Appeal Decision

Appeal Ref: APP/R5510/W/20/3261724

Land adjacent to 39 Southcote Rise, Ruislip HA4 7LN

- The appeal is made under section 78 of the Town and Country Planning Act 1990 against a refusal to grant planning permission.
- The appeal is made by Lagom Church Road Ltd against the decision of the Council of the London Borough of Hillingdon.
- The application Ref 74151/APP/2020/2097, dated 8 July 2020, was refused by notice dated 9 September 2020.
- The development proposed is the provision of 2no. 3 bedroom semi-detached dwellings with associated parking and amenity space and installation of 2 vehicular crossovers to the front.

DRAWING TITLE PROPOSED SITE LAYOUT PLAN (CONTEXT)

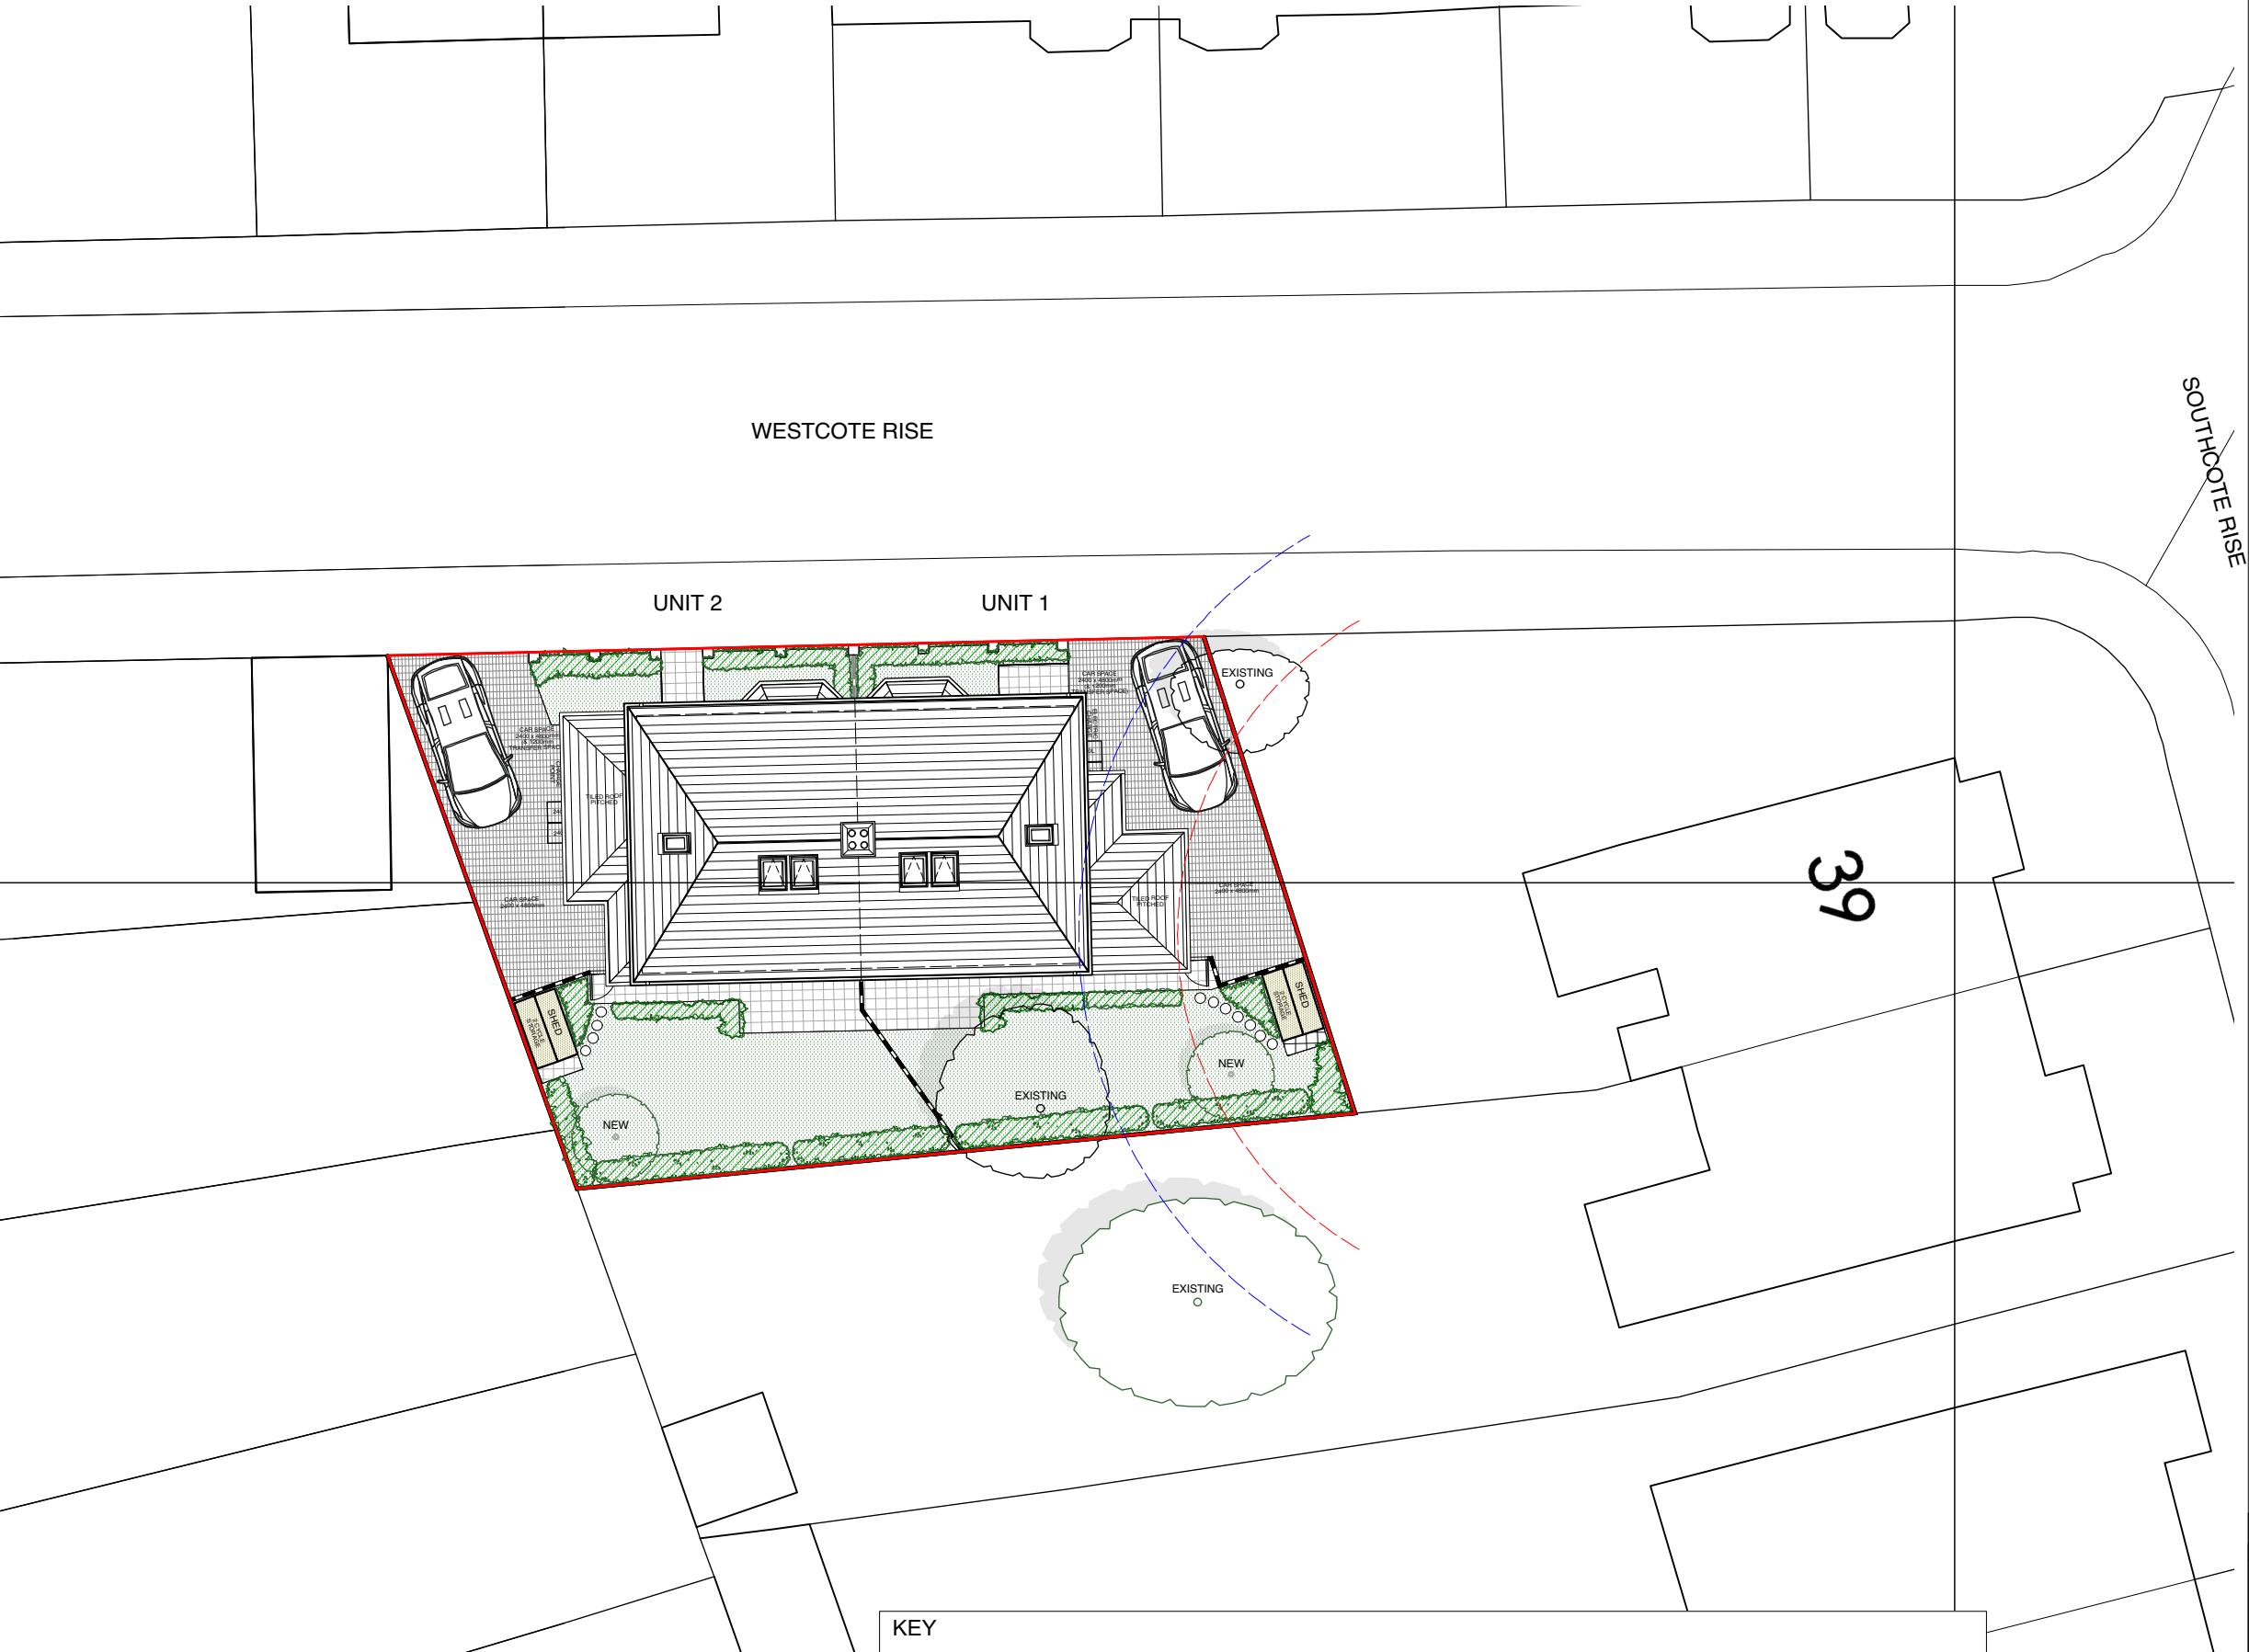
5. The appeal site was clearly used previously as garden for No 39 and, when viewed from the road, it has all the appearance of forming part of the garden, with its flank elevation abutting the rear of the pavement on Westcote Rise. The new fence and the formation of a separate title deed do not alter this, in my view.

6. The area is characterised by semi-detached houses with reasonably long rear gardens. Whilst many of the gardens are largely hidden from direct views, the degree of separation of the rear of the buildings is obvious due to the distance between the buildings and is revealed here where the rear gardens have a side boundary with the road. The proposal would place the pair of semi-detached houses close to the rear elevation of No 39. In addition, the new building would be uncharacteristically close to the boundary with the road. Furthermore, whilst I note that the Council's minimum amenity space requirement would be met, I consider that the space around the new dwellings, particularly at the front and rear, would be uncharacteristically cramped.

8. The existing house at No 39 is set at a slight angle to its plot boundaries. Within its rear elevation there is a conservatory at the ground floor and what appears to be a bedroom at the first floor. There is also a patio area and garden to the rear of the house. Notwithstanding the slightly angled siting, I consider that the proposal would be clearly seen from within the rooms at No 39 that I have identified. From here the proposal would appear unreasonably close. In addition, when within the rear garden at No 39, the proposal would appear unduly dominant and oppressive.

PROJECT SOUTHCOTE RISE
CLIENT LAGOM LONDON
DRAWING TITLE PROPOSED LOFT FLOOR & ROOF PLANS
SCALE 1:100@A3 DATE MAY 2020 DRAWN SC CHECK SC
PROJECT NO. DWG NO. REVISION
20018 111 P4

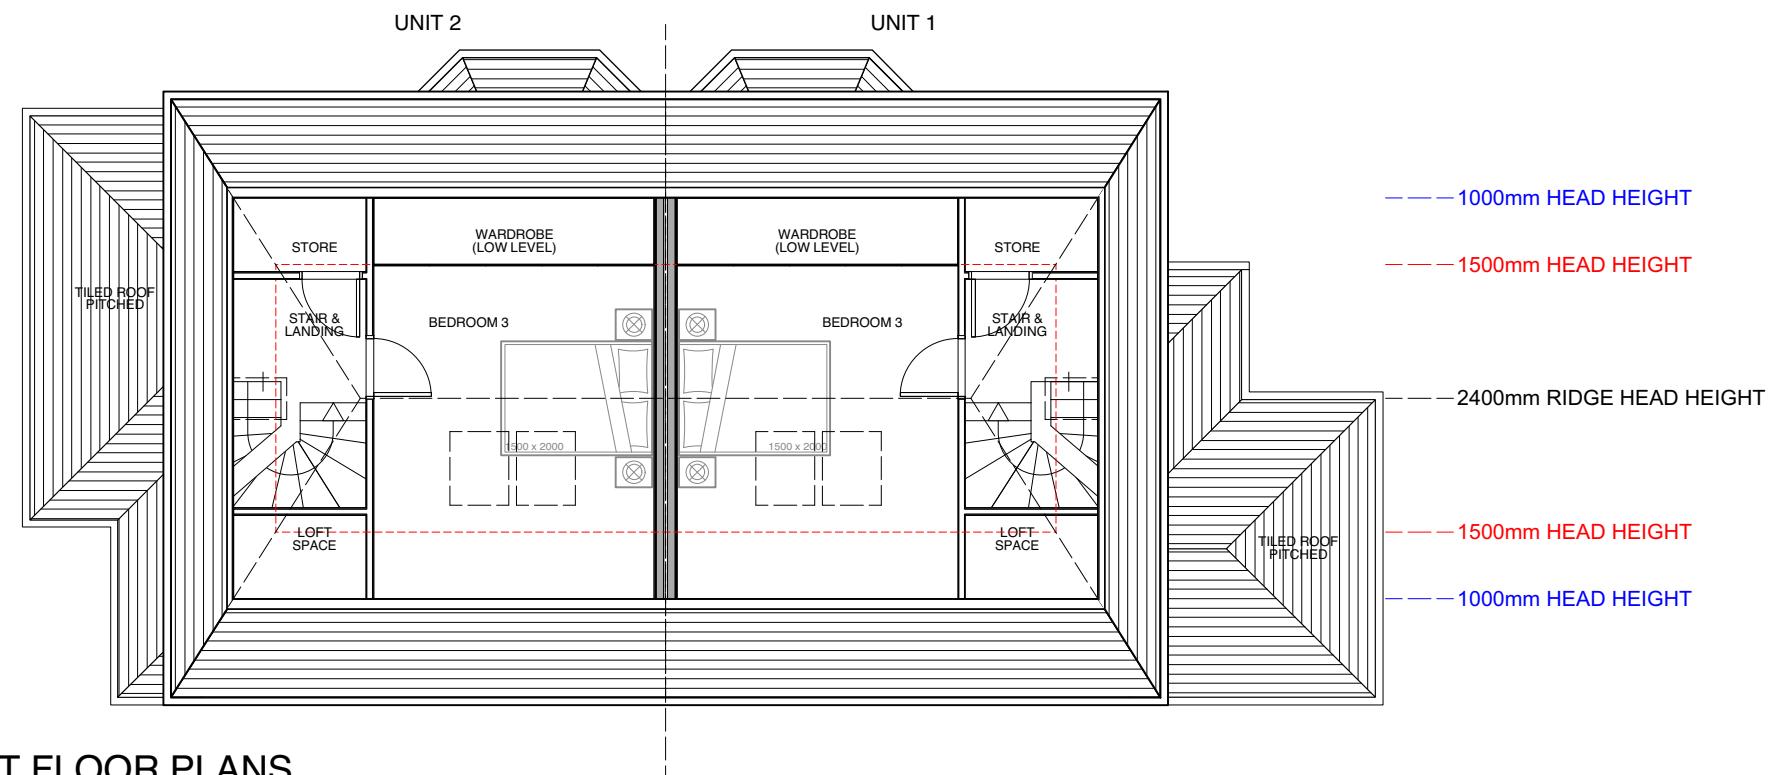
10. In relation to the proposed bedroom 3 within the roof space, if the roof-lights were to be lowered, as is suggested by the appellant, this could add to the potential for overlooking of the adjacent garden. For these reasons, the proposal is in conflict with Policy DMHB 11 of the DMP.

11. The proposed bedroom 3 of each house would be contained within the roof-space and served by rooflights. These are indicated to be at high level. In my judgement, this would fail to provide a suitable outlook from this bedroom and conflicts further with Policy DMHB 11. The prospect of revising the position of the roof-lights could resolve this but would give rise to additional unacceptable overlooking as set out above.

3 PROPOSED REAR ELEVATION
SCALE: 1:100

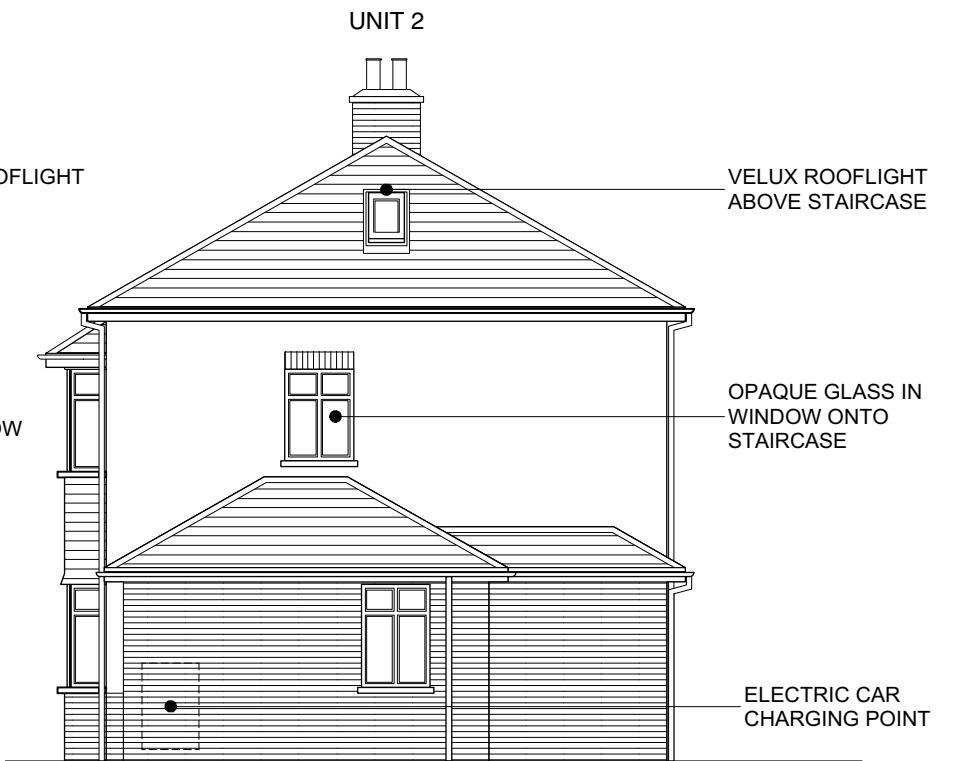
9. Although not specifically raised by the Council, neighbouring residents suggest that the living conditions of others would be affected by the proposal. The very short proposed rear gardens and the proximity of the proposed building to the nearest gardens of houses on Southcote Rise and Orchard Close means that the proposal would have a similar dominating effect when seen from those gardens. In addition, the rear garden of No 37 Southcote Rise would be close to the rear elevation of the proposed houses, which would contain bedroom windows. I consider that this would be particularly disconcerting for residents at No 37 when using the rear section of their garden from where they would feel unacceptably overlooked. I do not consider that the possibility of landscaping here would provide an adequate screen, and there would be no
